RE: GAA 21028 - Manor Court, High Street, Harmondsworth, UB7 0NL

27256/APP/2021/3805 MANOR COURT Details of external materials in
HIGH STREET compliance with condition 4

27256/APP/2021/3759 MANOR COURT Details of Landscaping in compliance with
HIGH STREET condition 6

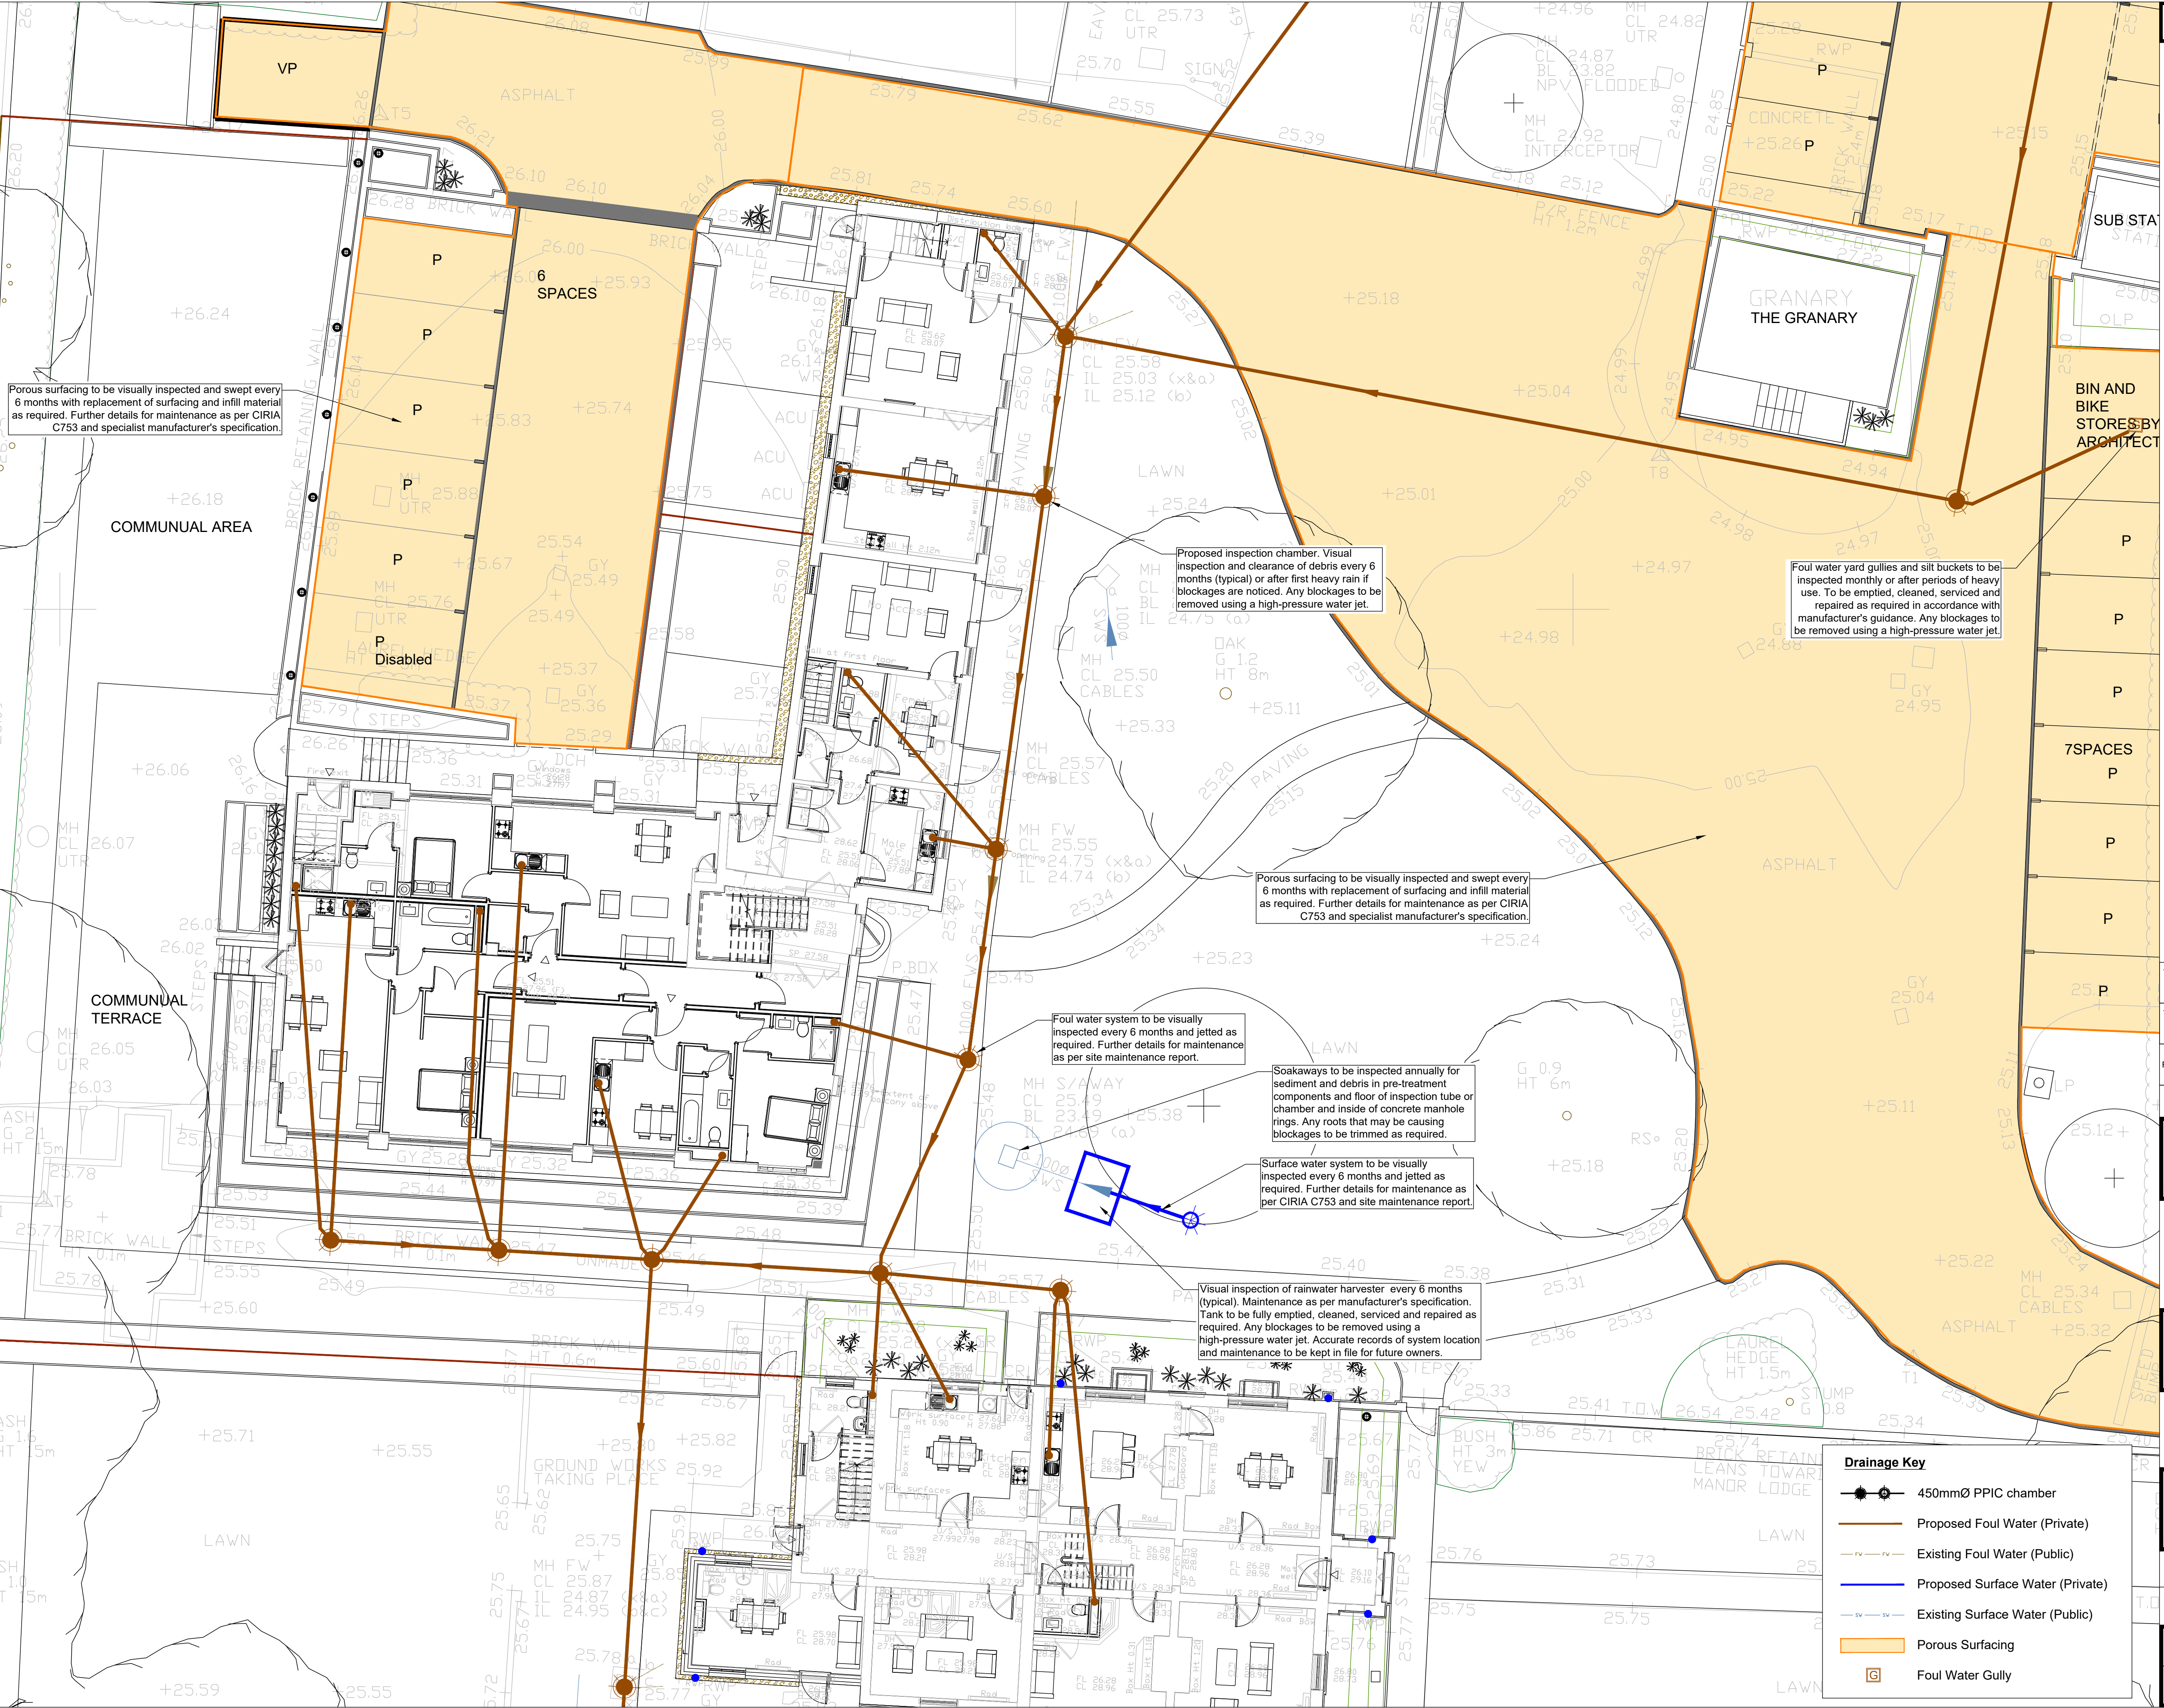
Condition 7 – SUDs – Consultant has come back with the comment below, do confirm if these are acceptable:

“If the porous surfacing is to be installed on top of the existing surfacing, then this will act as a temporary layer and will need to be perforated with holes at max 1m centres to allow water to pass through from the porous layer. If attenuation is required in the clean stone of the porous surfacing system, then this must be laid on top of the existing surface so that the storage is required. If this is not possible then the existing surface must be removed to allow the correct build up of media to attenuate and allow infiltration of the surface water”
